# **KIRKLEES METROPOLITAN COUNCIL INVESTMENT & REGENERATION SERVICE**

### **DELEGATED DECISION TO DETERMINE APPLICATIONS FOR CONSENT, AGREEMENT OR APPROVAL REQUIRED BY CONDITION**

| Reference No:         | <b>2025/44/90881/W</b>                                                                                                                                                                                                                                                                 |
| Description:          | Discharge of details reserved by conditions 5 (parking provision), 6 (car park management), and 9 (landscape management) of previous Reserved Matters approval 2023/93655 pursuant to (Phase 2 of) outline permission 2021/91544 for erection of health and research innovation campus |

Image 2.2 Southgate Campus Car Park Provision

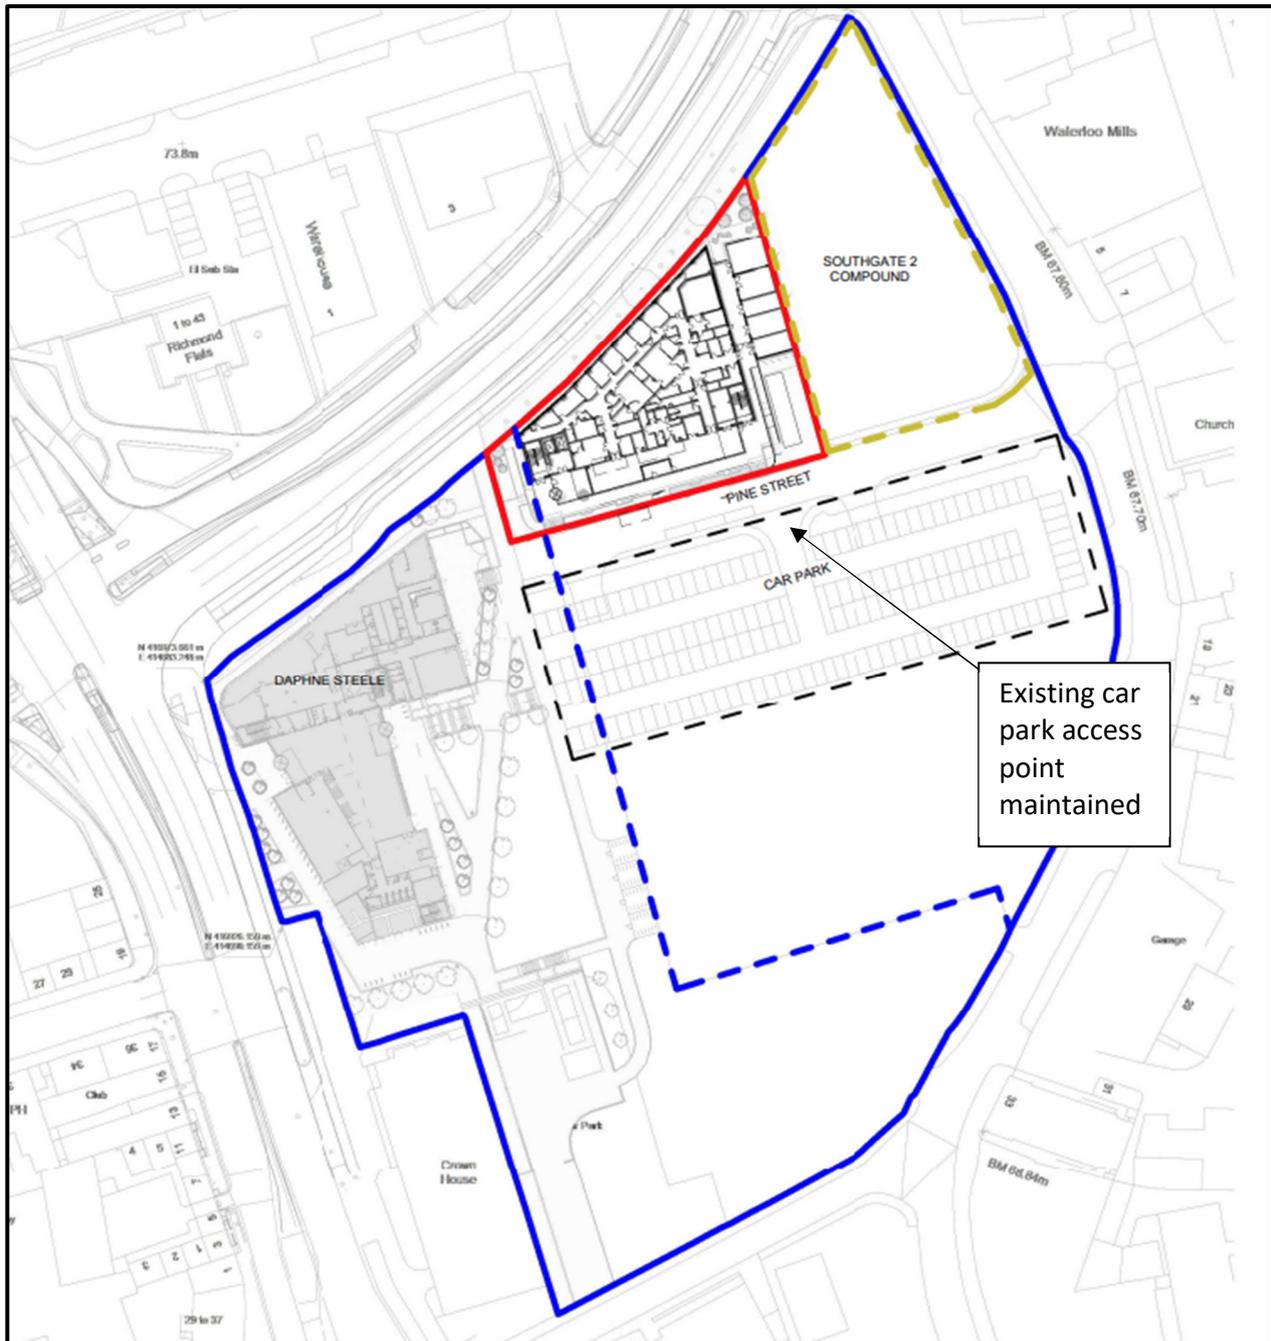
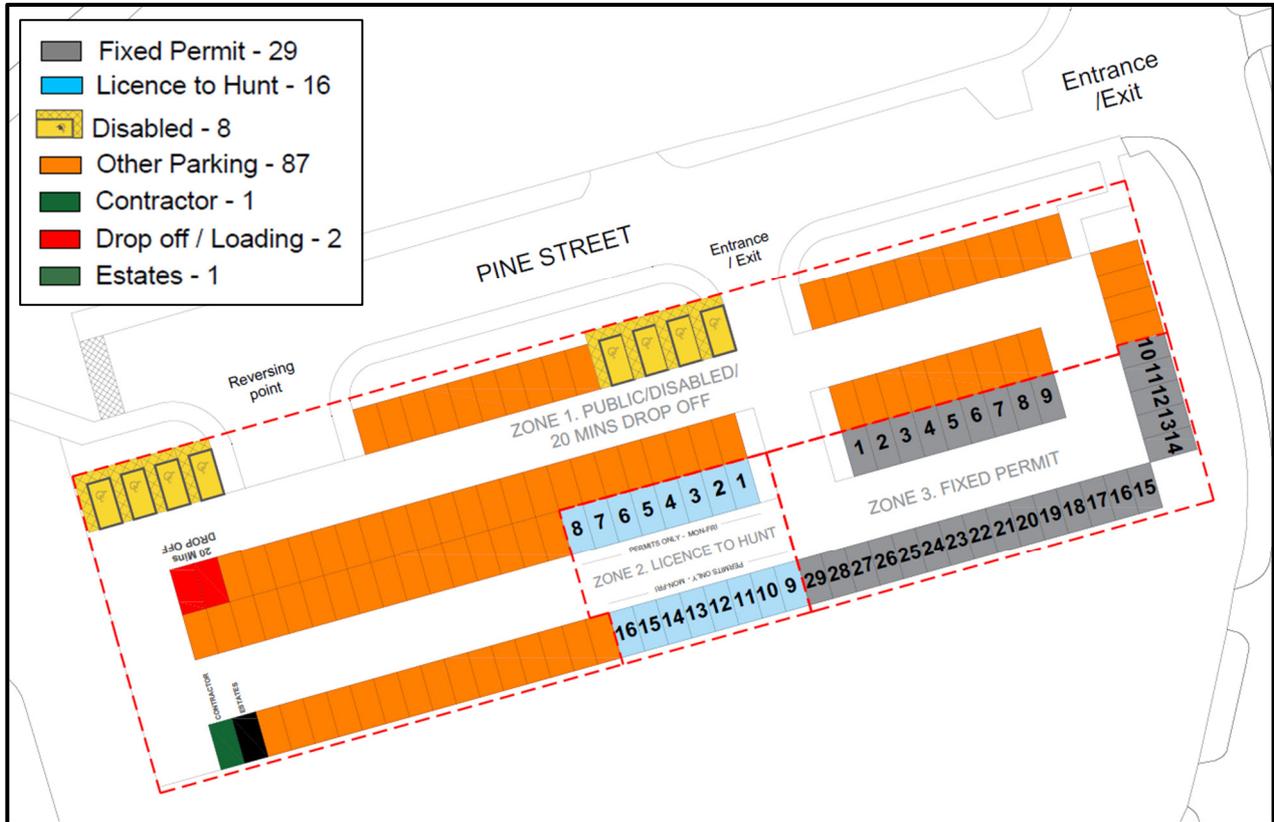
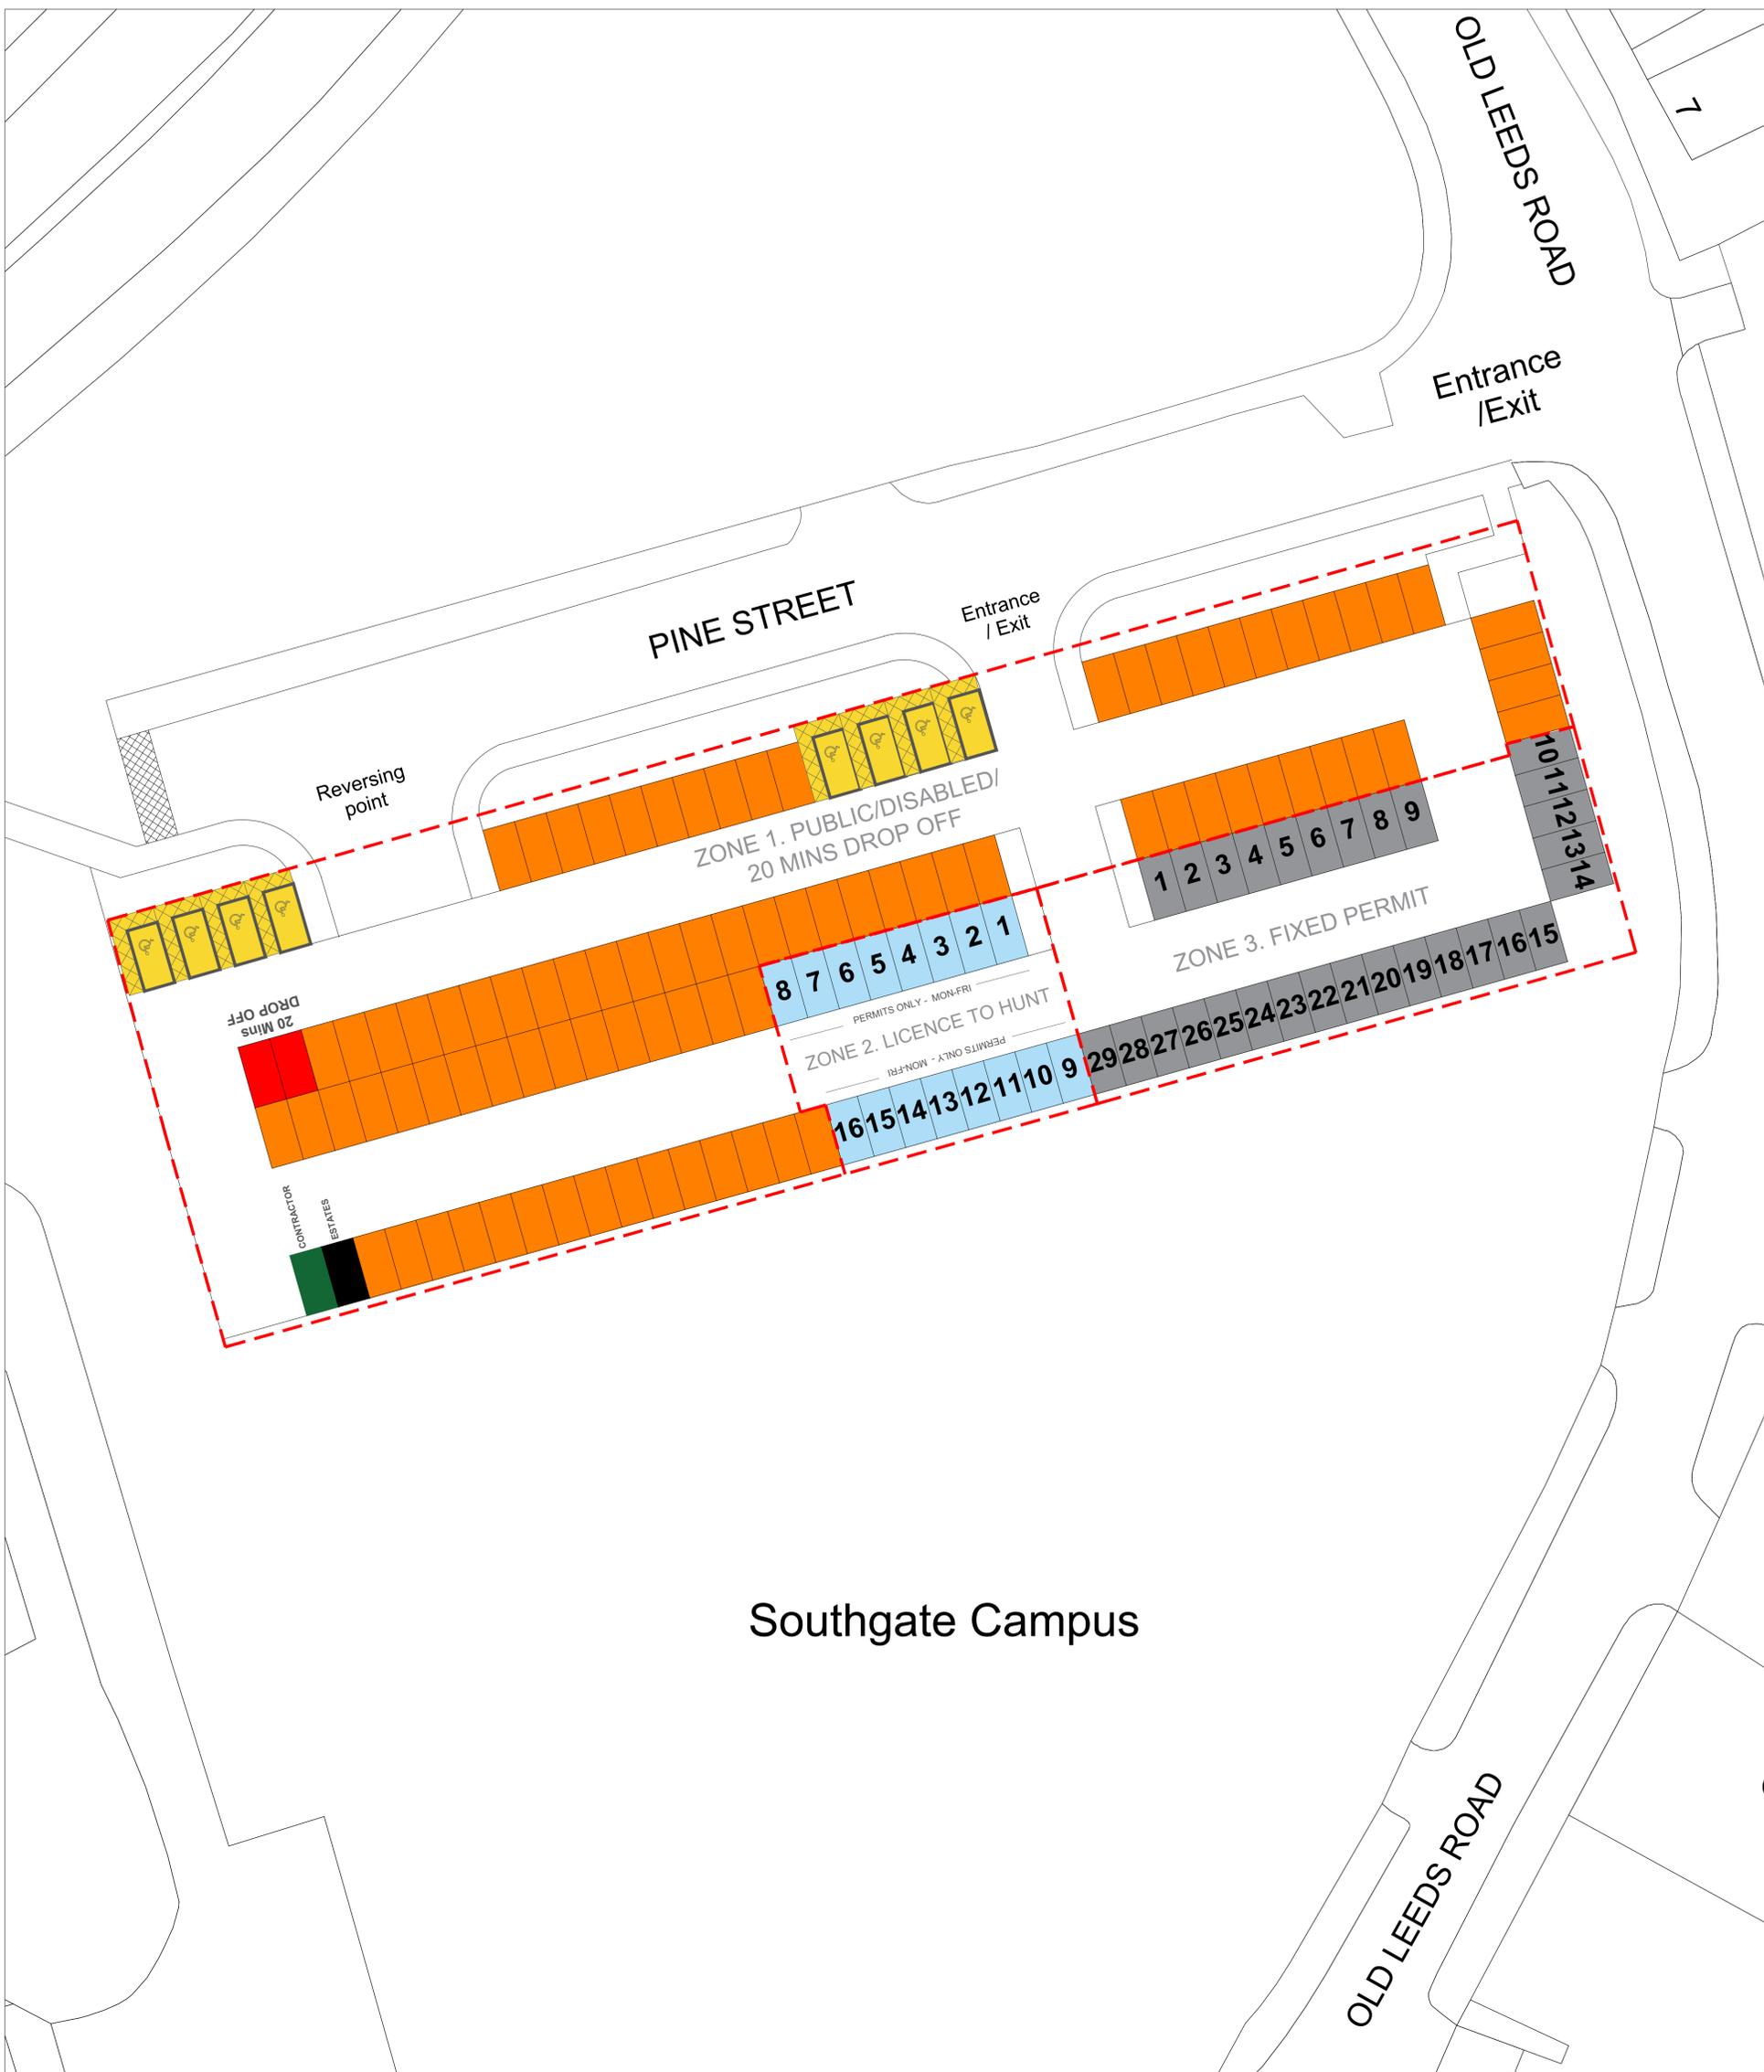
The applicant initially submitted a Car Park Management Plan (Optima, 11004, March 2025) pursuant to condition 5. Within that document, Images 2.1 and 2.2 and Appendix A illustrated a car park of 144 spaces directly to the south of

The proposed car park includes 45 permit spaces (29 fixed and 16 “licence to hunt” spaces), 8 accessible spaces, 2 contractor/estates spaces, 2 drop-off spaces (limited waiting time of 20 minutes) and 87 public pay and display spaces. None of these are specifically dedicated to Phase 2 unless they are assigned within the permit spaces.

As noted in their comments of 24/04/2025, KC HDM considered that the provision of 144 spaces, shared between the two current phases of the development (Phases 1 and 2, the Daphne Steele Building and the Emily Siddon Building), along with the controls set out within the Car Park Management Plan (considered below in relation to condition 6), were adequate.

KC HDM also noted that the Car Park Management Plan as initially submitted excluded details of payments and stay limits for general daytime use by patients of and visitors to the medical units within the Daphne Steele Building and the Emily Siddon Building. KC HDM suggested that the document would be amended to account for this future use of the Emily Siddon Building.

A revised version of the Car Park Management Plan (Optima, 11004, rev 1, June 2025) received on 24/06/2025 did not change the proposed parking provision described above.

It is, however, noted that condition 6 includes no requirement for the document to be updated and resubmitted at a later stage (although further submissions are likely to be required in relation to other phases of the wider development) – Reserved Matters condition 6 only requires one submission in relation to Phase 2. Officers therefore asked the applicant to address the above matter in a revised version of the Car Park Management Plan. This (Optima, 11004, rev 1, June 2025) was duly submitted on 24/06/2025. Sections 2.5 and 2.6 include new and revised details regarding staff and visitor parking. Paragraph 2.6.1 confirms that public parking would be available during building operating hours to accommodate patients attending clinics. Paragraphs 2.6.3 and 4 provide set out parking charges, and how payments would be made. Stays of up to 12 hours are referred to. This information adequately addresses KC HDM's request for details of payments and stay limits for general daytime use for patients and visitors to the medical units within the Daphne Steele Building and the Emily Siddon Building.
